Subject: AL/106/19/DOC

Further to my previous response to this application for Condition 7 (CMP), I asked for further detail on their complaint procedure in the CMP should there be a lighting complaint. They have just stated 'in the event of any queries or concerns the site manager is contactable'. Given that we have already had a lighting complaint about this site, I would appreciate it if they could expand more to advise of their complaint procedure in the event of a lighting complaint. I am satisfied with the noise part of the CMP, now they have put more detail into it.

REV. No.	DATE	DESCRIPTION	INITIALS
Client			
Project	Westergate & Eastergate		
Title	External Works Layout Sheet 1	Scale 1:250@A0 Checked AMc	Date Mar '18 Drawn KT
Drawing No.	5655:40	Rev	H

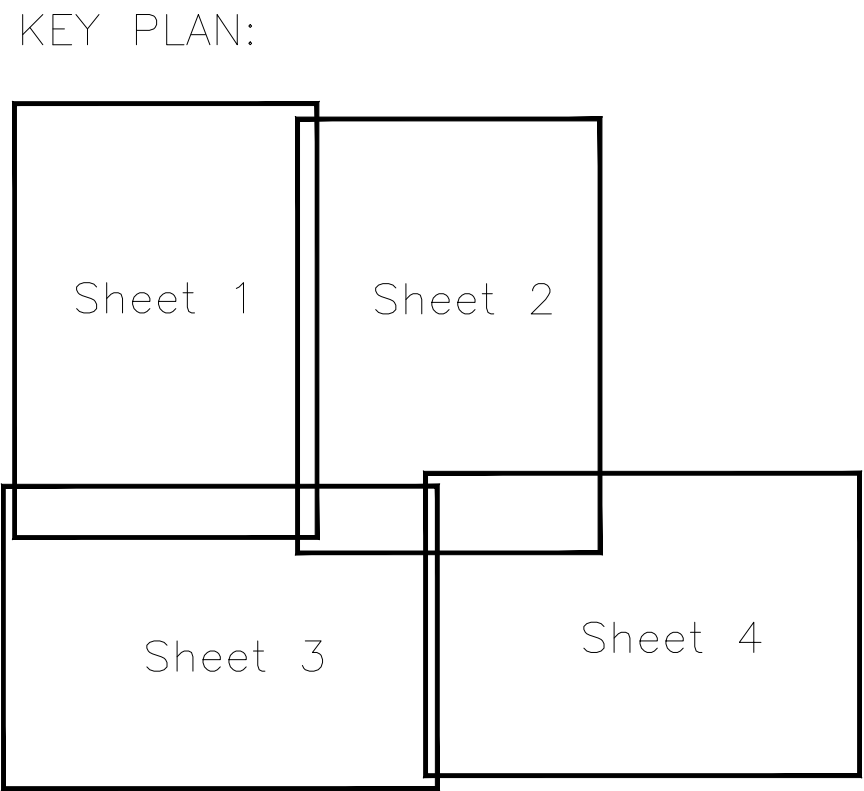
I haven't been able to find confirmation of the fact that the Lighting Schedule complies with Zone E2 of the ILP guidance – as discussed there are a couple of documents that the Planning Portal seems intent to keep me away from! If you could point me to the documentation that contains the Zone E2 confirmation I would be very grateful.
